**Date:** 07 April 2026

**STATUTORY PLANNING CONSULTATION RESPONSE**

<b>Application Number:</b>	3/2026/0238
<b>Proposal:</b>	Approval of details reserved by conditions 3 (construction management plan/method statement) 4 (surface water) 5 (bat boxes) 7 (street maintenance) 8 (flood mitigation) 9 (flood management plan) 10 (surface water/foul drainage) 19 (cycle storage) 20 (travel plan) and 21 (operation/maintenance manual) on planning permission 3/2022/1158 granted on appeal APP/T2350/W/25/3368139.
<b>Location:</b>	Land South of Accrington Road Whalley

CONSTRUCTION SURFACE WATER
MANAGEMENT PLAN

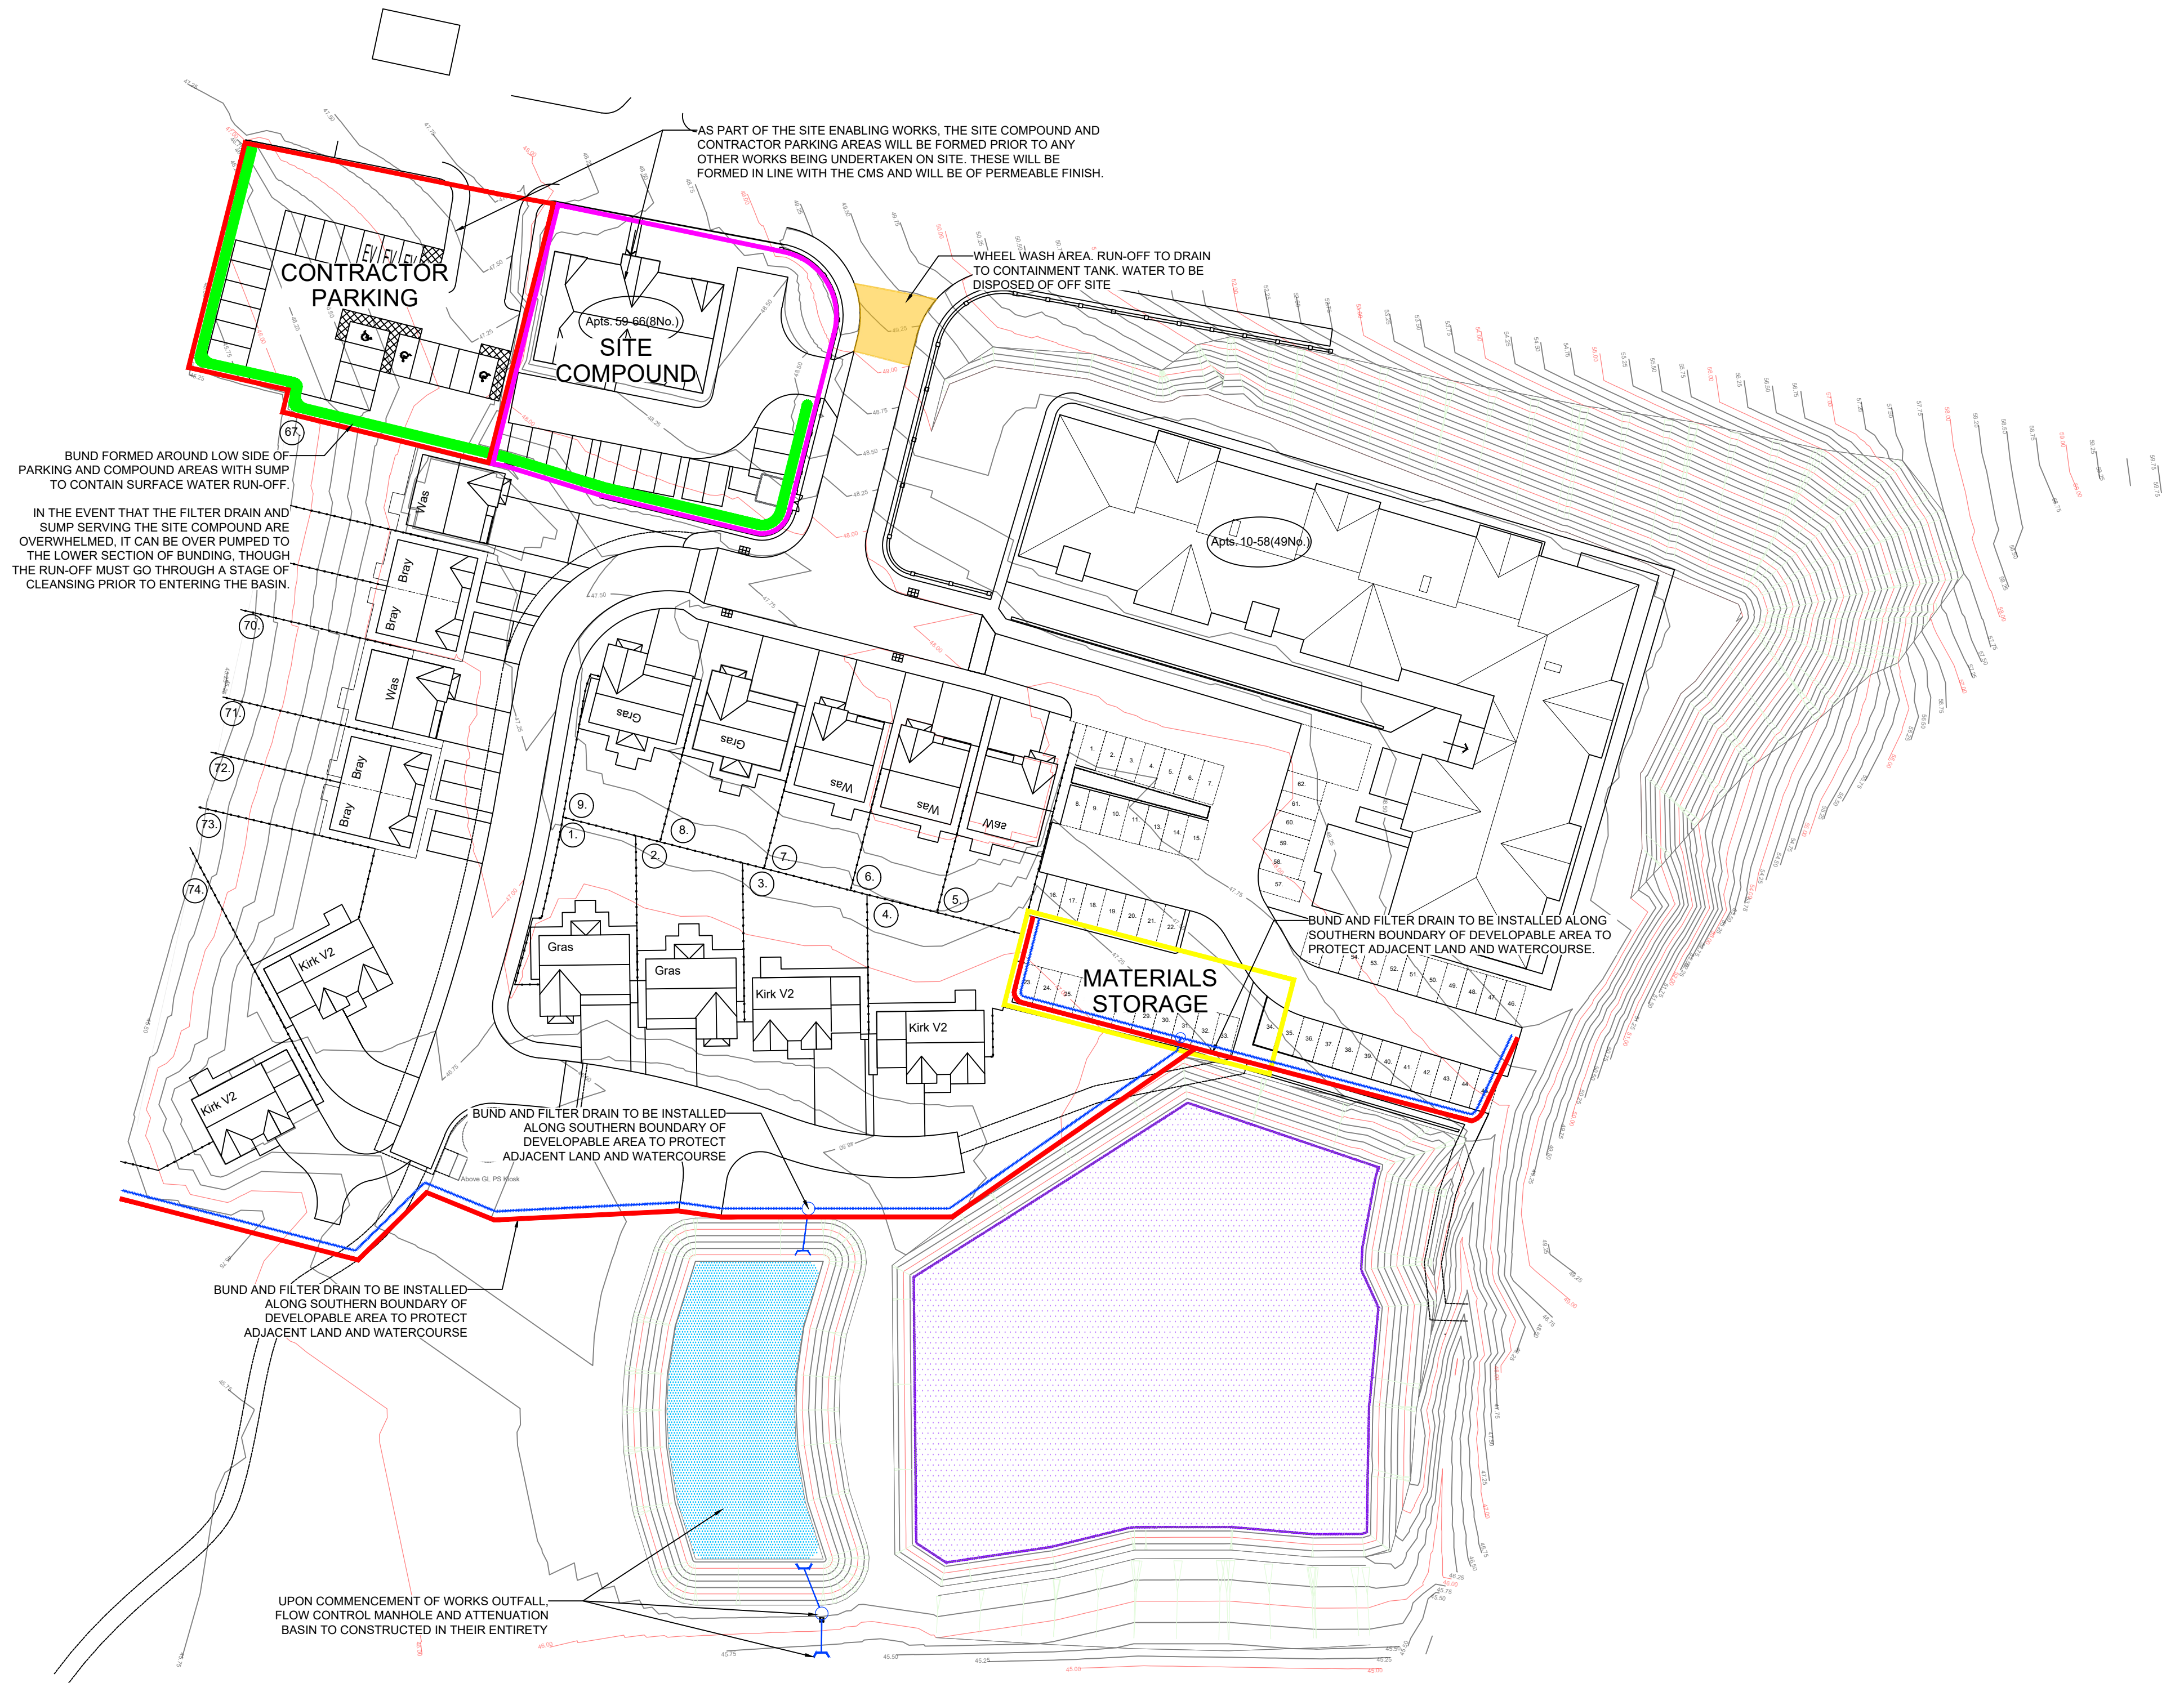
- The applicant has failed to provide clear evidence of a layout plan demonstrating the location of any proposed silt and pollution mitigation measures, in regard to surface water management during the construction phase. In addition to this, it is

unclear how the applicant intends to control the discharge of surface water prior to / during construction of the attenuation pond or the proposed final hydrobrake.
